**From:** [Charles Judson](#)  
**To:** [A47 Blofield to North Burlingham](#)  
**Subject:** A47 Blofield - North Burlingham - Hearing Action Points  
**Date:** 06 September 2021 13:18:09  
**Attachments:** [Acle Neighbourhood Plan extract - policy 5.pdf](#)

Please accept the following responses on behalf of Broadland District Council to the Hearing Action Points:

Issue Specific Hearing 1 – Draft Development Consent Order (dDCO) - Tuesday 17 August 2021

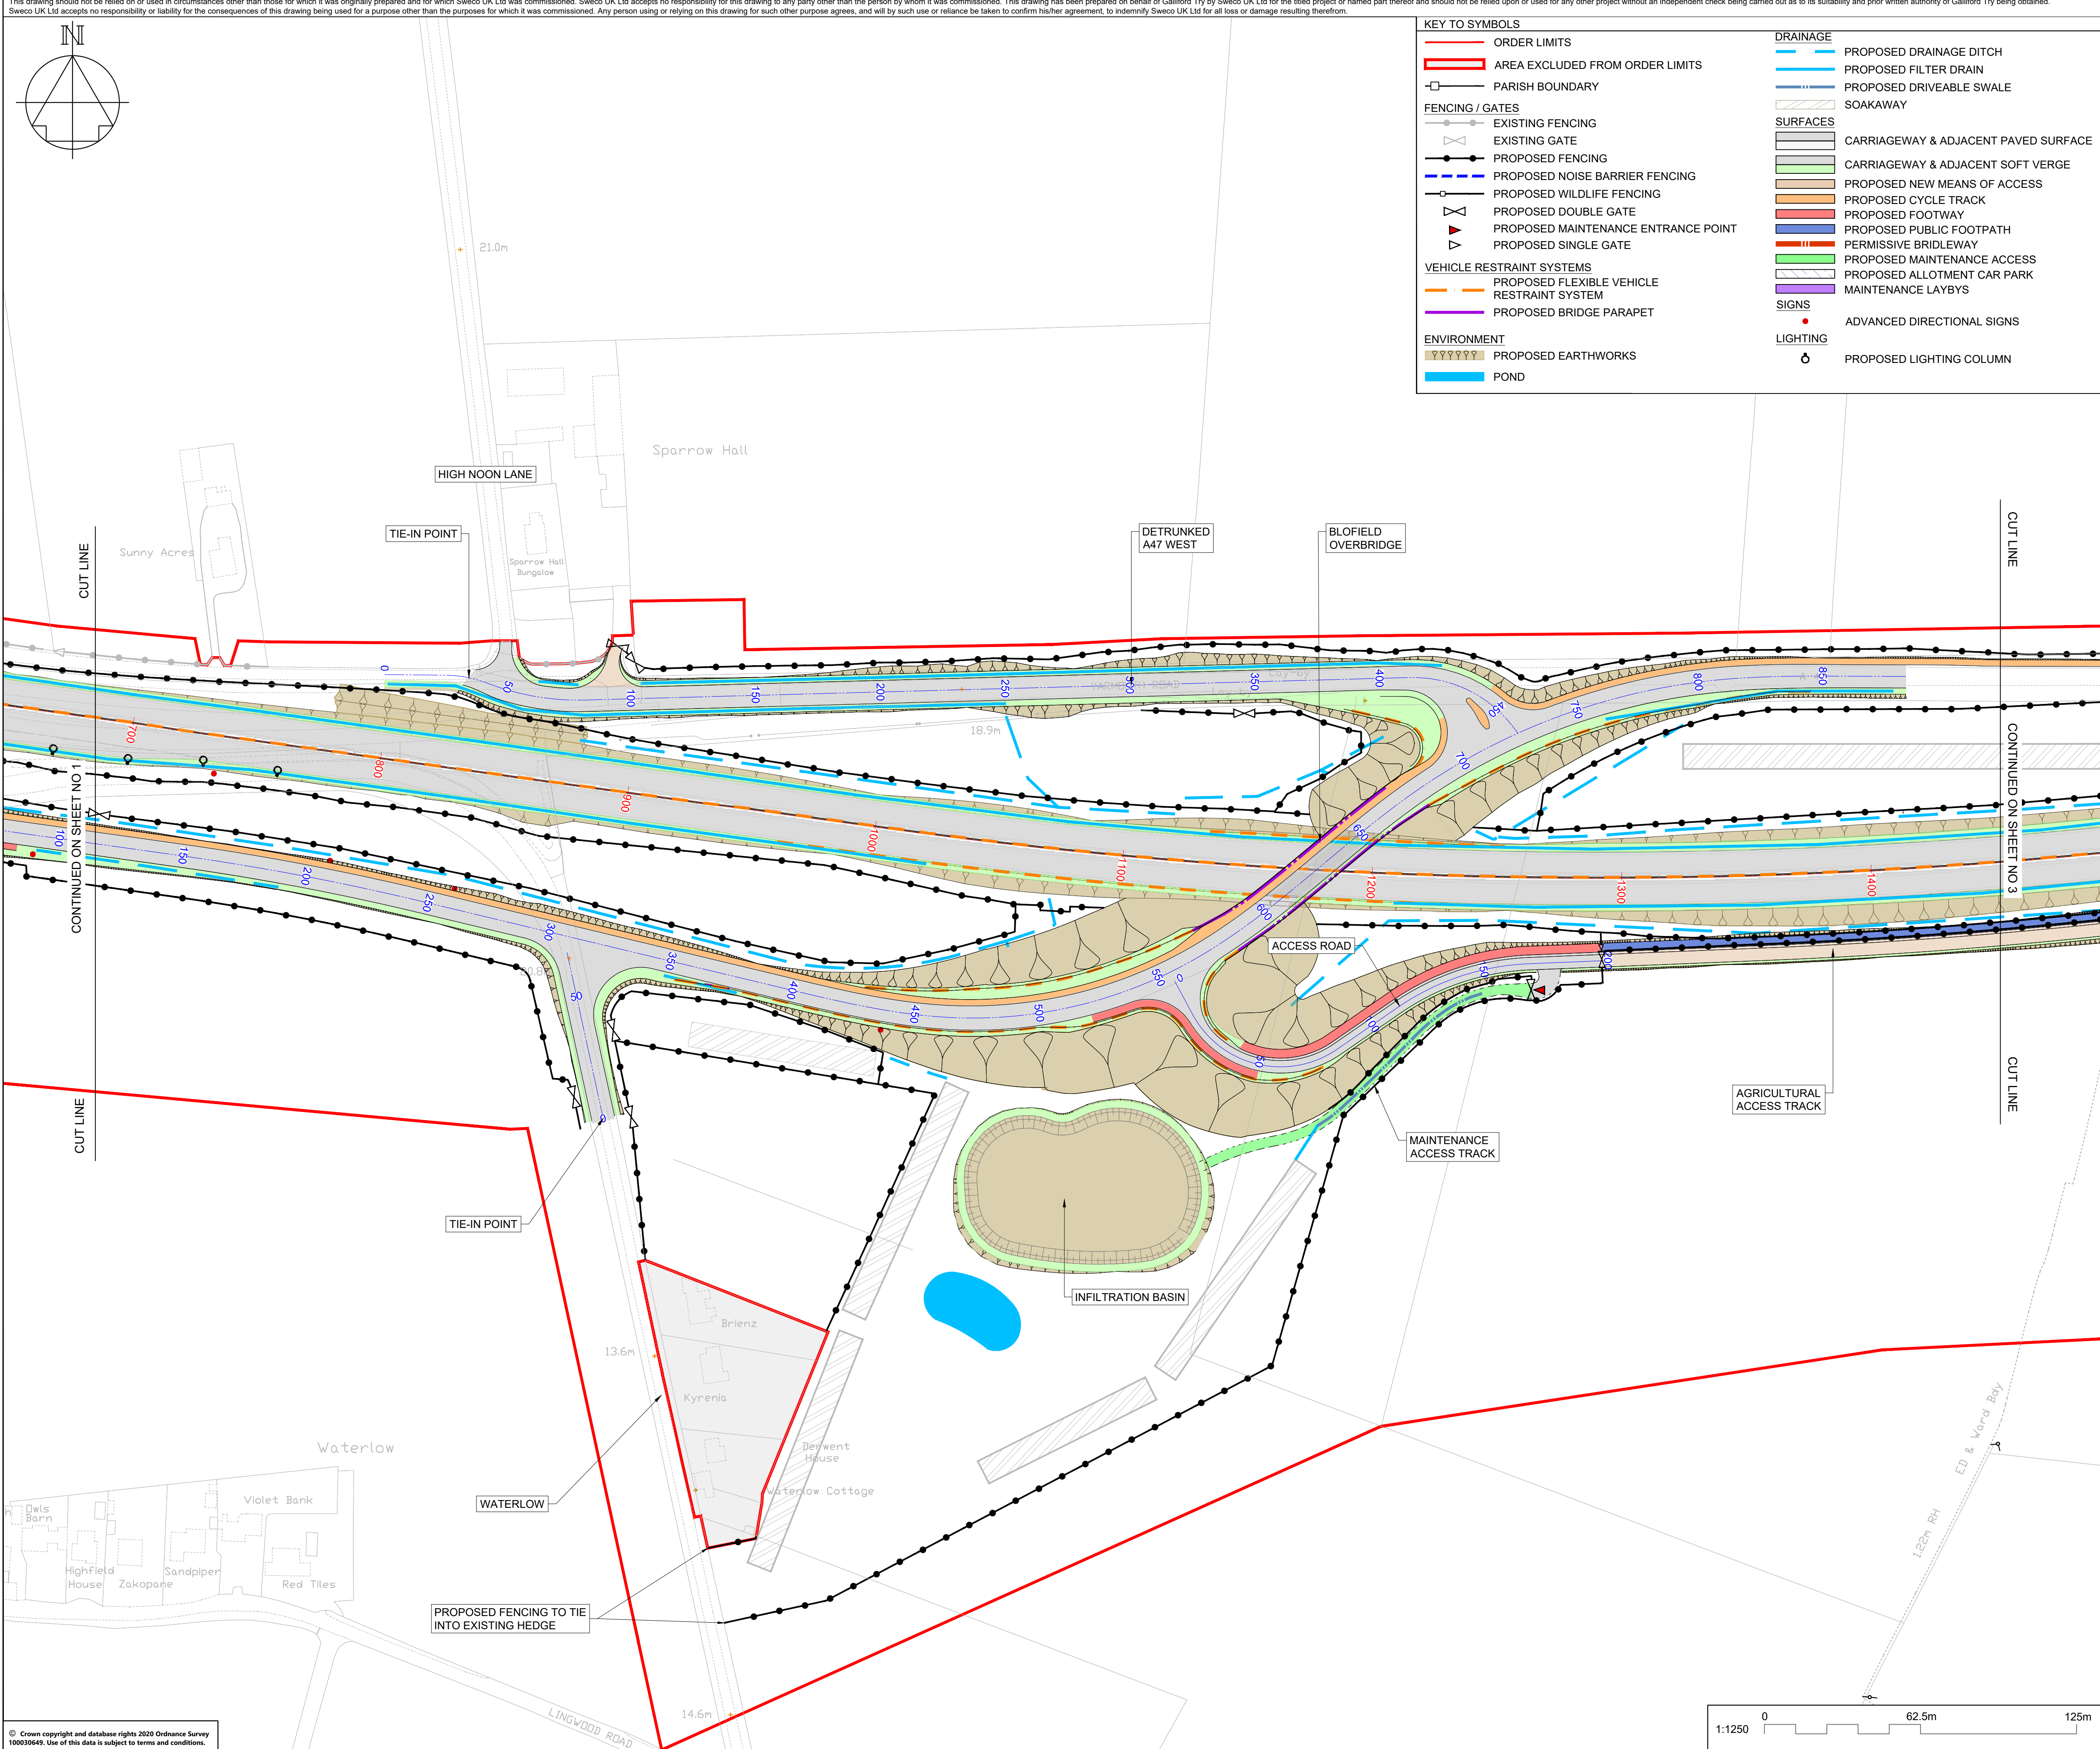
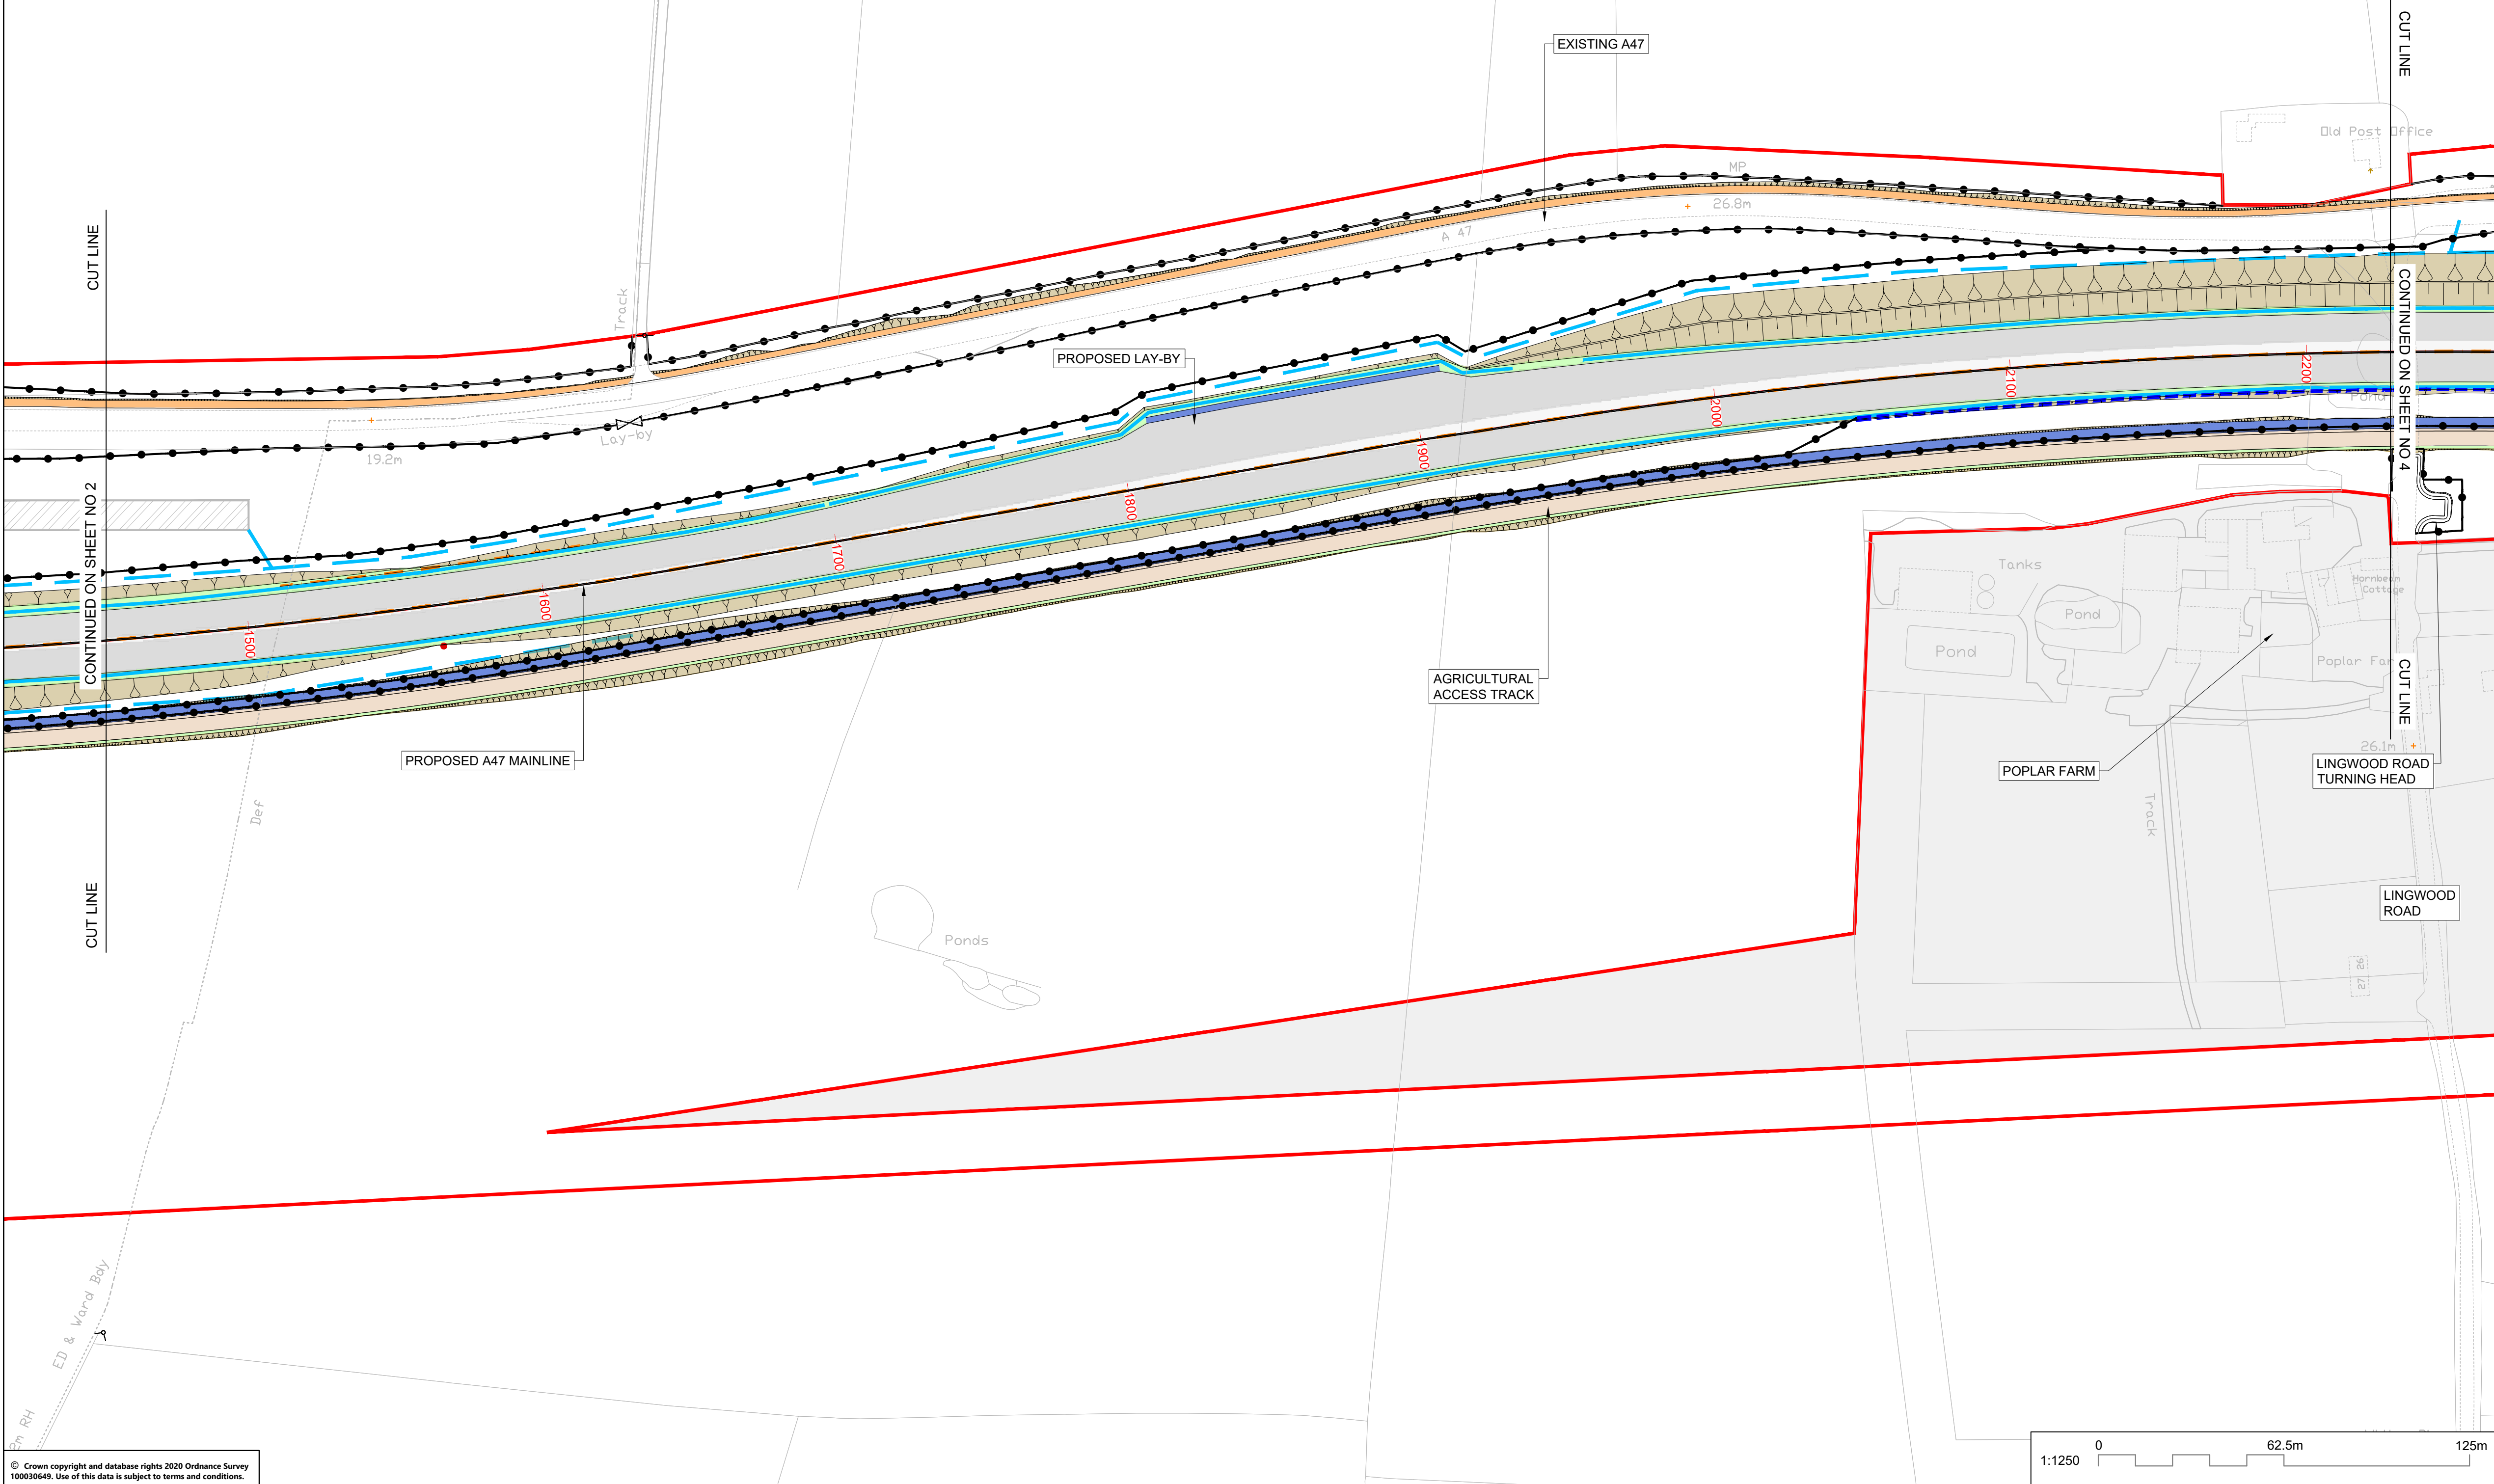
Item 11 – Broadland District Council considers that the general arrangement plans, which do not include details of elevations/sections/design/materials of the structures, would be insufficient for the purposes of R3.
